RE: 1363 Washington Ave

Thank you for sending the final detail sheet for this project that includes the dumpster enclosure. I have copied this to Malia and Kyle as all of the other submissions have come through them to me.

GATE DETAILS N.T.S. **6**

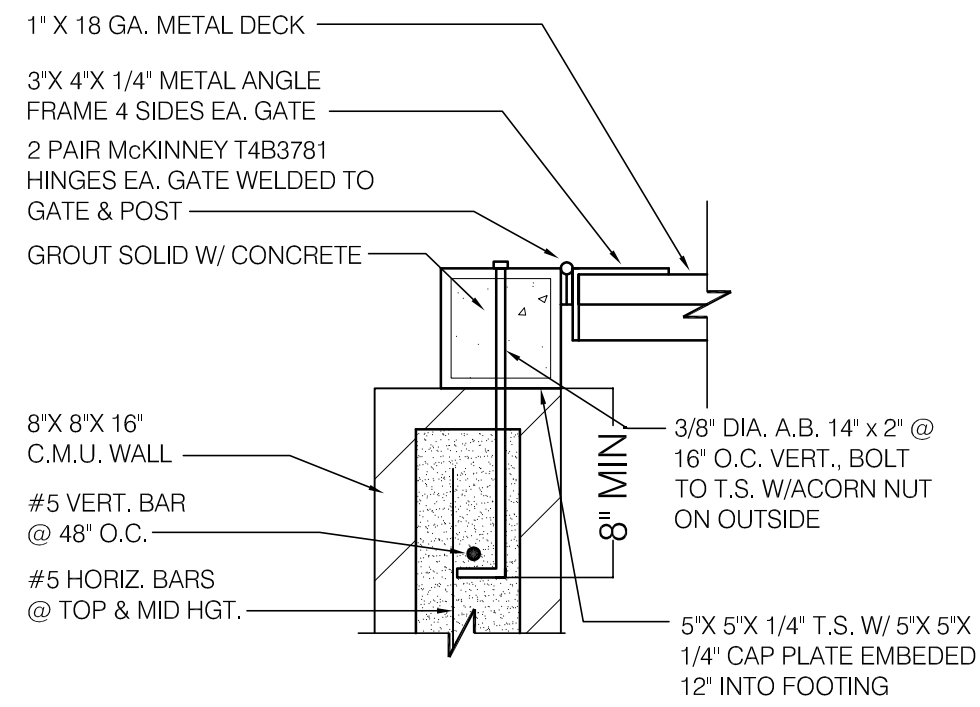
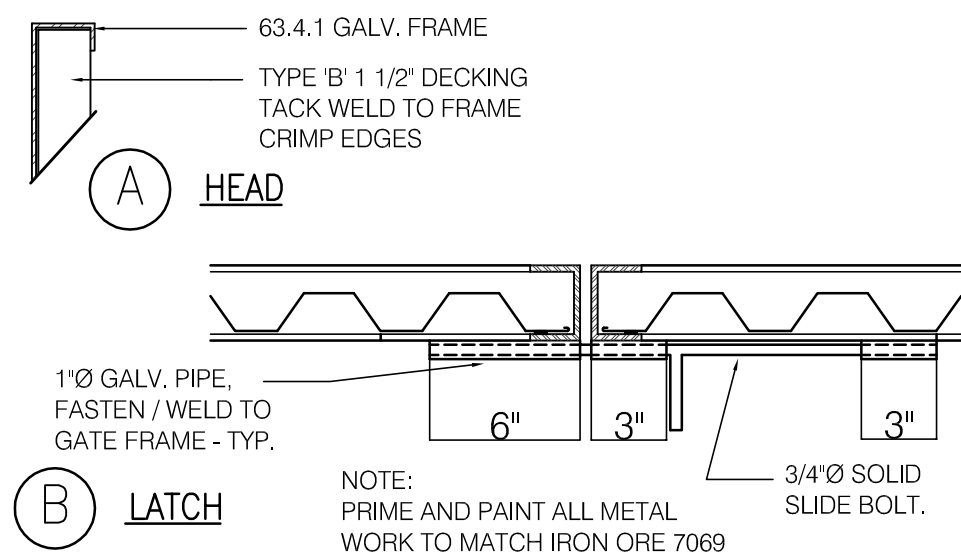
Regarding the dumpster detail- the objective is for the dumpster to be screened and hidden if possible- this is an urban area with lots of pedestrians and nearby buildings/users so it should not be highlighted with yellow posts etc. **Dumpsters will be screened with the CMU wall and metal gates. Steel supporting the gates will be painted a color to match the building color, Sherwin Williams 7069 – ‘Iron Ore’.**

What is the material on the sides and back? **8x8x16 split face CMU on the sides and back of the enclosure.**
